CITY OF ALBUQUERQUE

September 22, 2015

**Re: Signal Pointe Subdivision
Signal/Ventura
Grading and Drainage
Engineers Stamp Date 8/20/2015 (C20D070)**

Based upon the information provided in your submittal received 8/21/2015, the above referenced Grading and Drainage Plan is approved based on the following conditions:

CMU RETAINING WALL / SCOUR WALL SECT. A

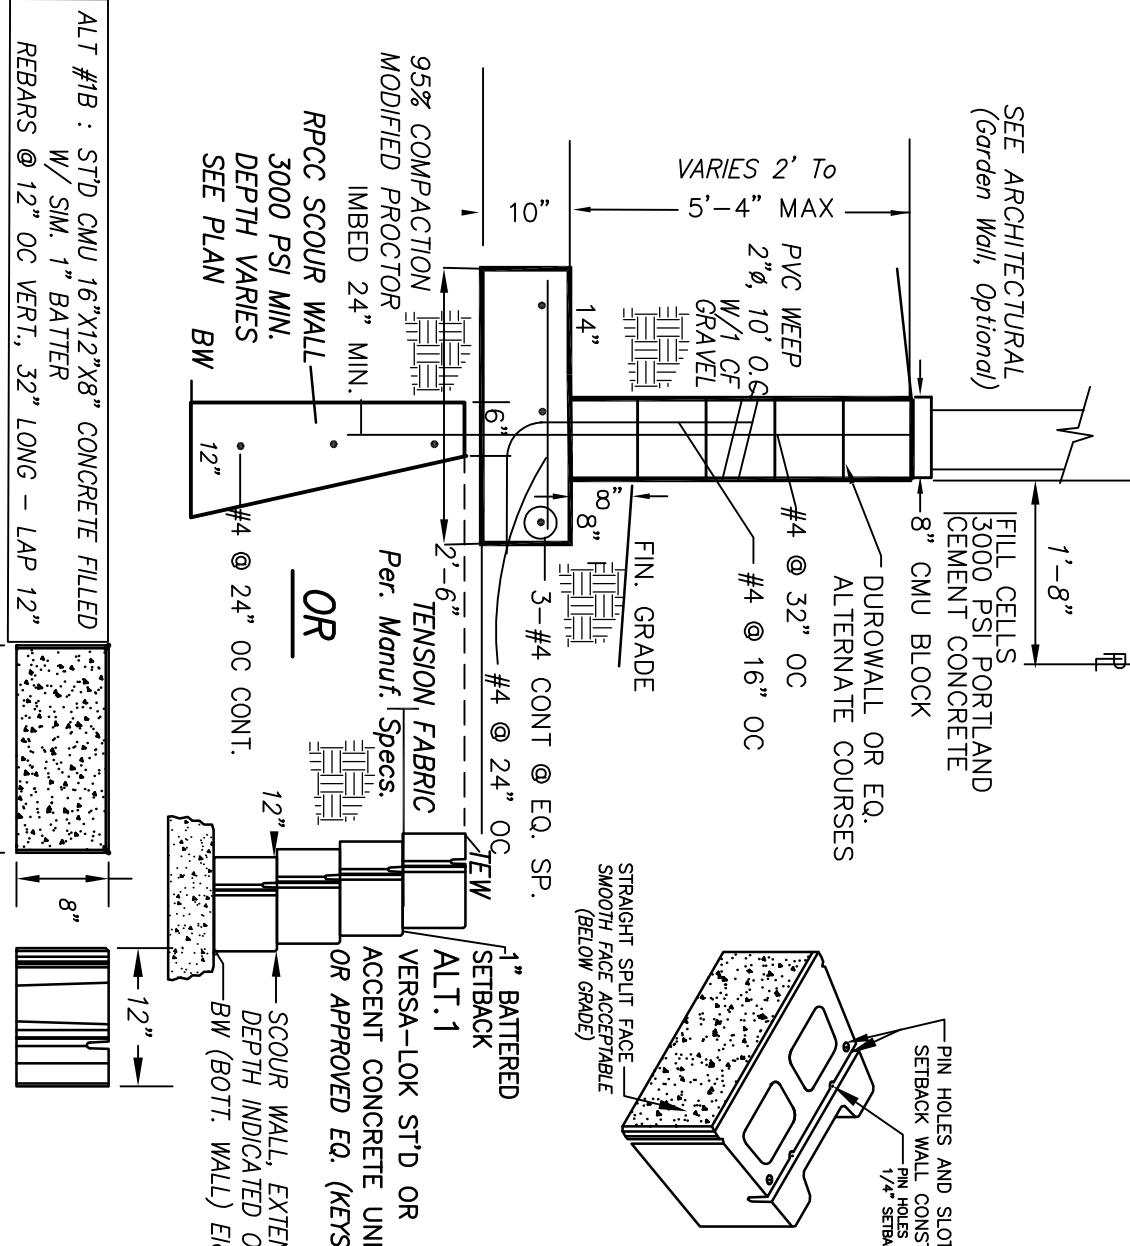
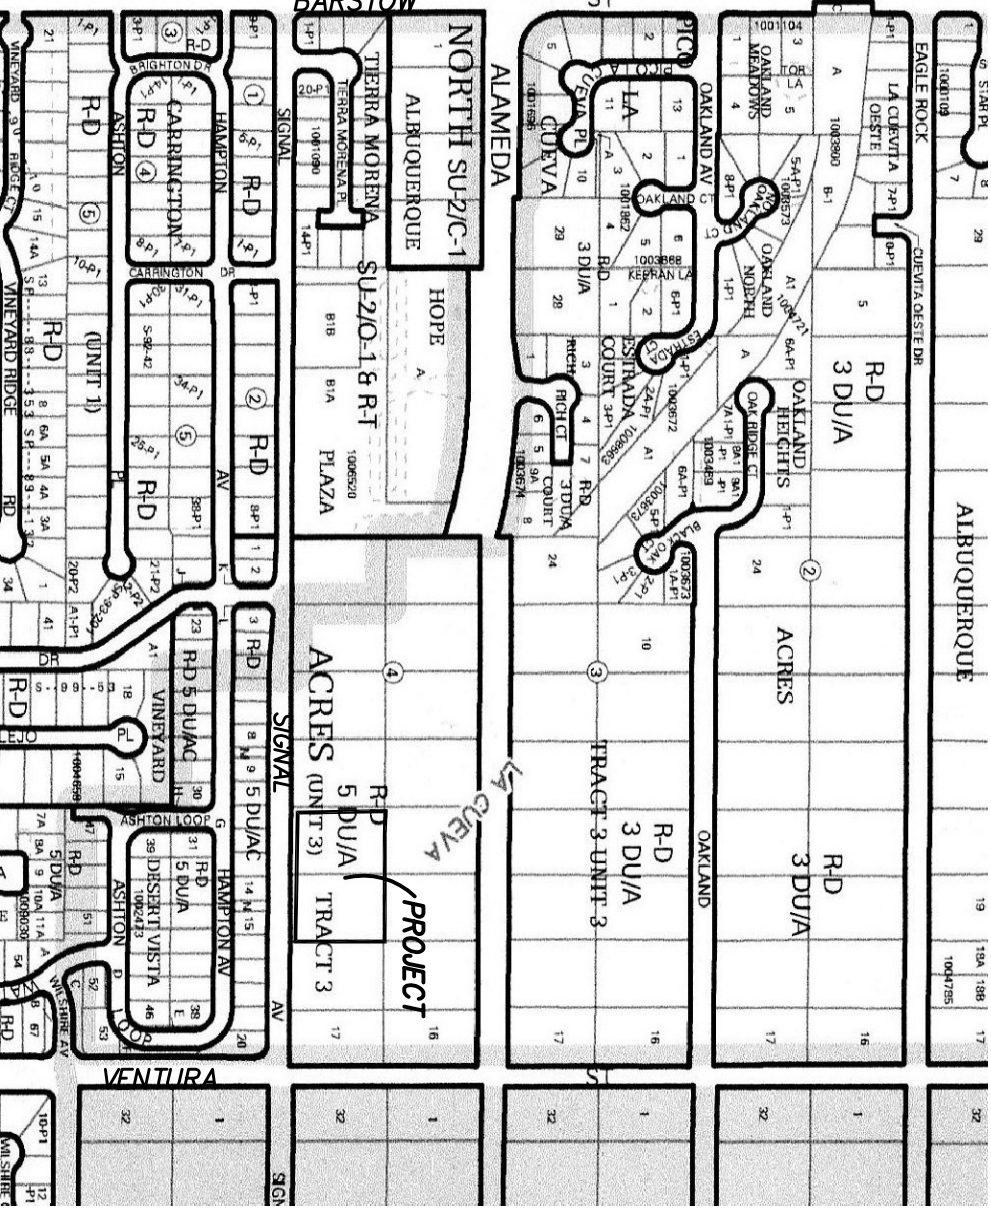
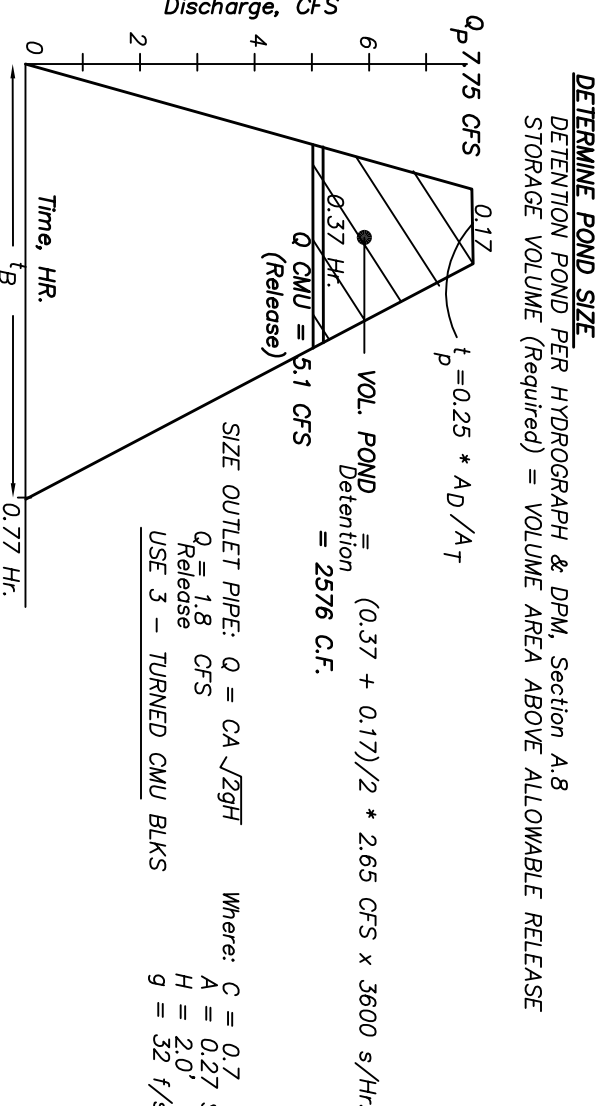
- The wall should remain in place once the erosion occurs. Please design the flood control structures accordingly. The wall detail/calculations/specifications must be clearly shown on the DRC plans.
- Provide plan and profile sheets for the flood control structure including the top and bottom elevations.
- Clearly show the limits (including stations) of Riprap Erosion Control Lining shown on Section A and the proposed floodwall on the DRC plan.
- Grading Certification will be required prior to release of Financial Guarantee, Workorder and building permits.
